August 28, 2020

El Paso County Planning and Community Development Department
Attn: Ms. Nina Ruiz
2880 International Circle, Suite 110
Colorado Springs, CO 80910

Re: Responses to the following comments, Round 3, EA Number EA1881, File Number AL2014:

FIGURE 2 - Reclamation Plan Map with HEC-RAS Cross Sections

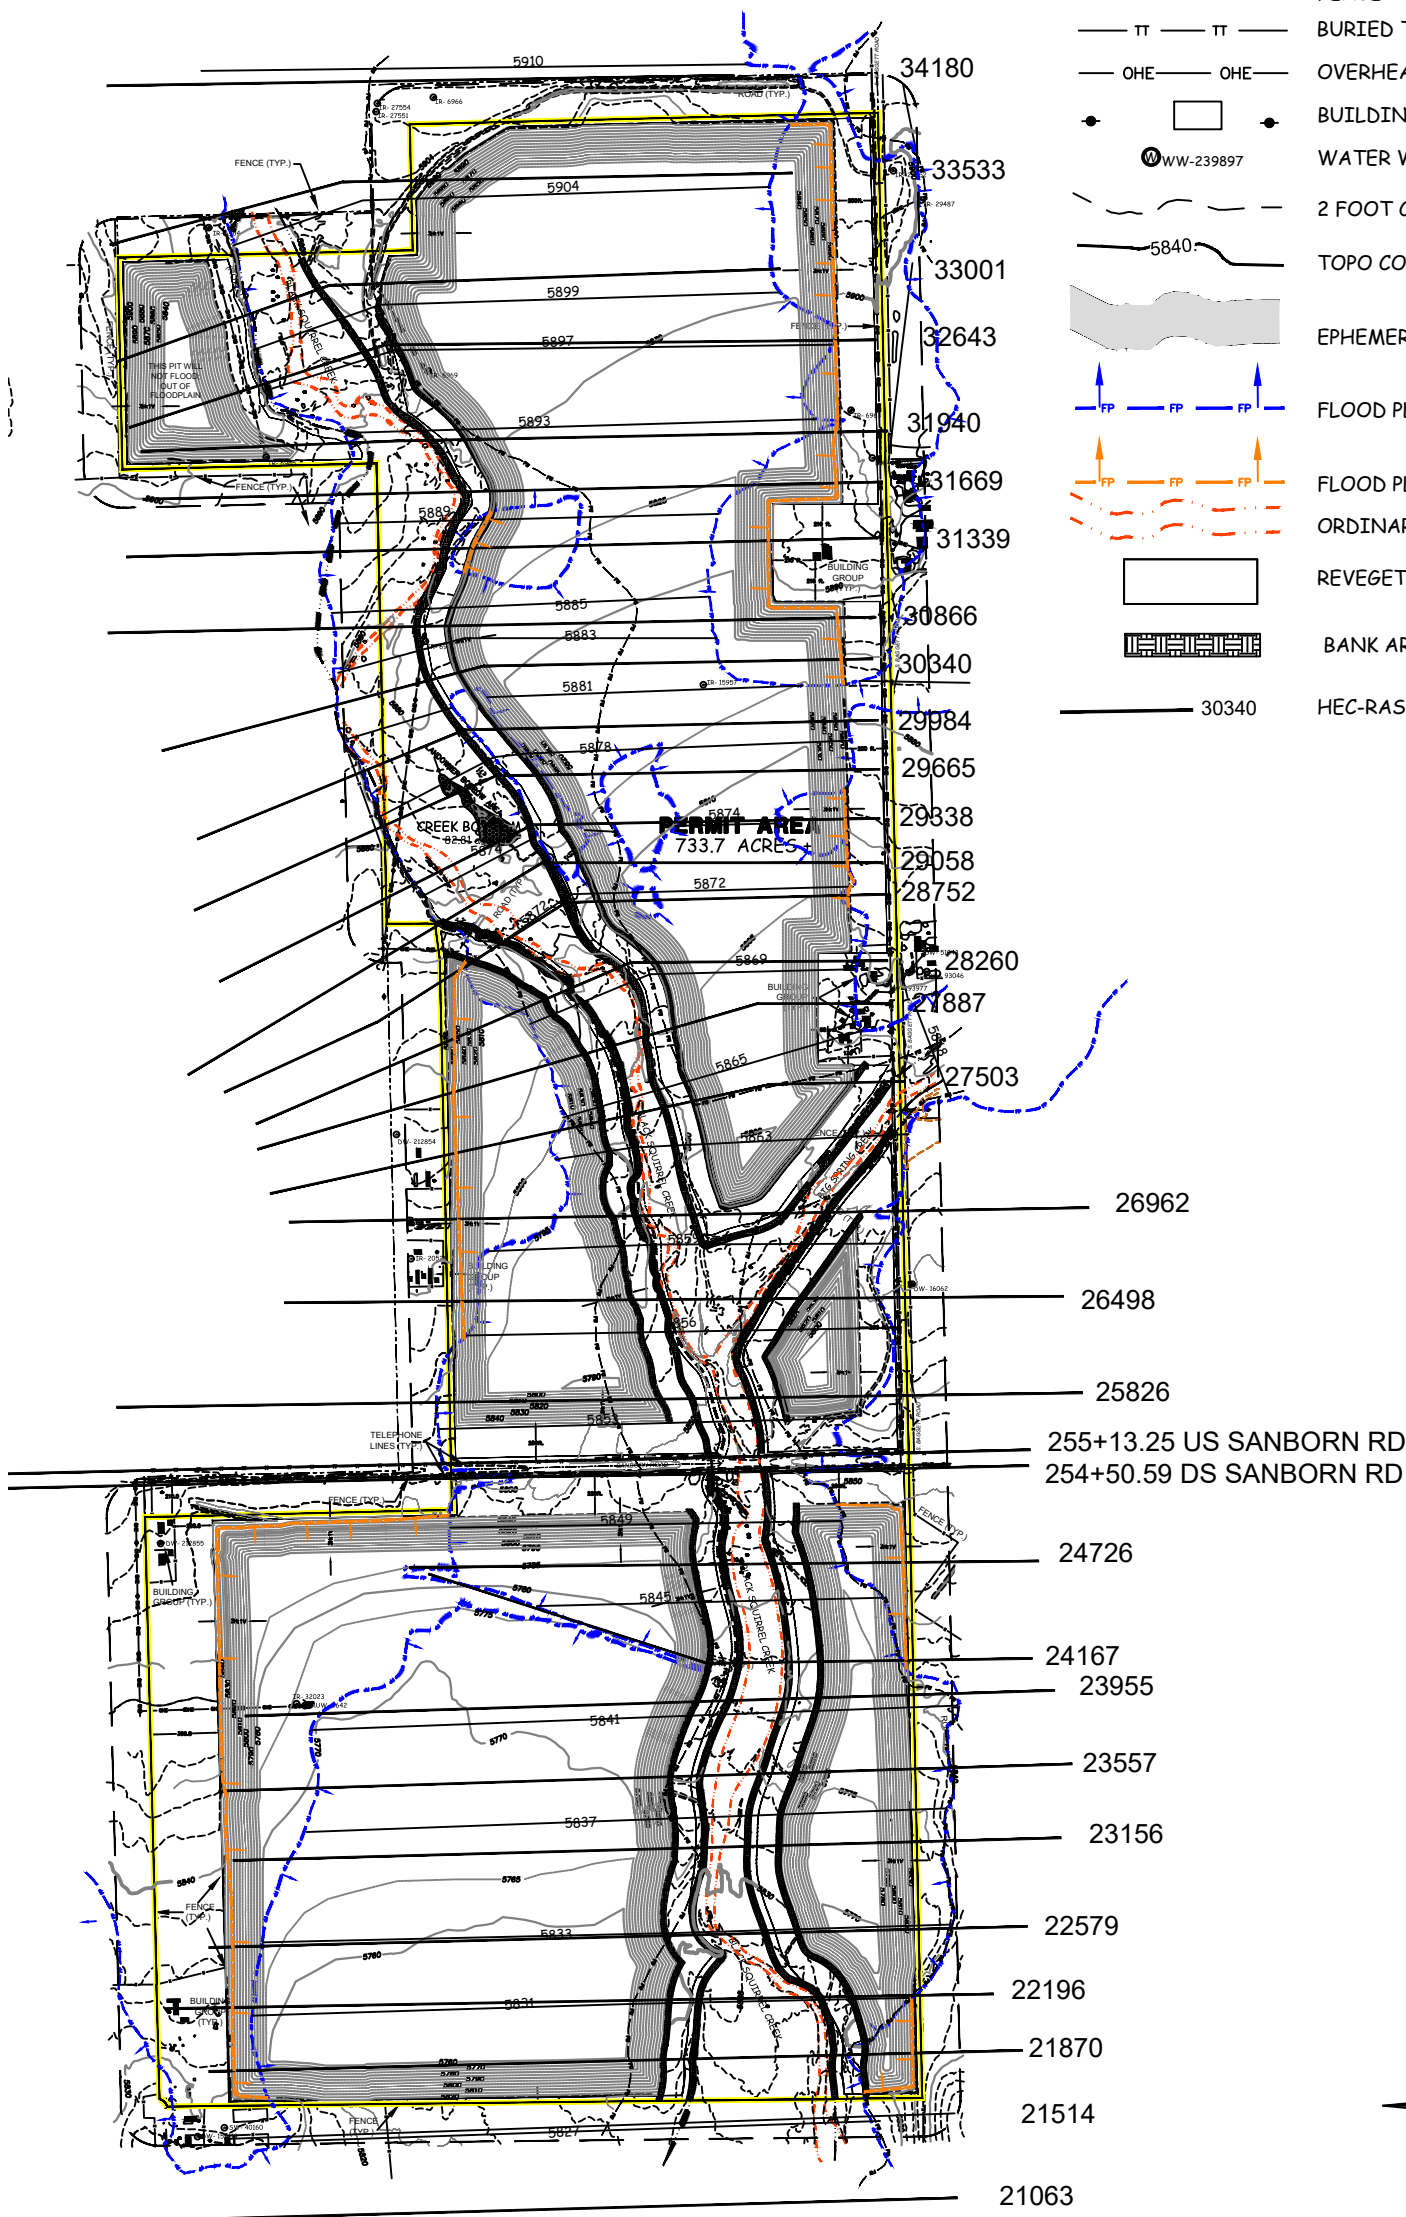
- *“Applicant’s letter of Intent indicates that mining operations will be set back 150 foot from Upper Black Squirrel Creek. Applicant’s Application for a Regular 112 Construction Materials Mined Land Reclamation, however, states that there will be a 50 foot setback. Applicant should reconcile these conflicting statements. And to the extent Applicant proposes a 50 foot setback, this distance is inadequate. The setback on both sides of Upper Black Squirrel Creek should be at least 150 feet from the side of the creek channel.”*

- ❖ The approved DRMS permit application was revised to show a 150-foot setback along all creeks adjacent to the mined areas, within the permit area. Based on the revised Reclamation Plan maps, the buffer between each creek and the final reclaimed 3H:1V slope is 150 feet. Plus, the slopes along the creek and the slopes at the top of the 3H:1V reclaimed slopes, adjacent to the creeks, are to be appropriately armored to resist failure during a high water, from storm water runoff event.

As noted in response to question 2, we have increased the setback to 150 feet and plan to install armoring on both banks along the river in accordance with the Urban Drainage Guidelines. Text has been added to the Mining Plan explaining how this will be done as mining progresses. A Bank Protection Plan is also attached for the Divisions review.
”
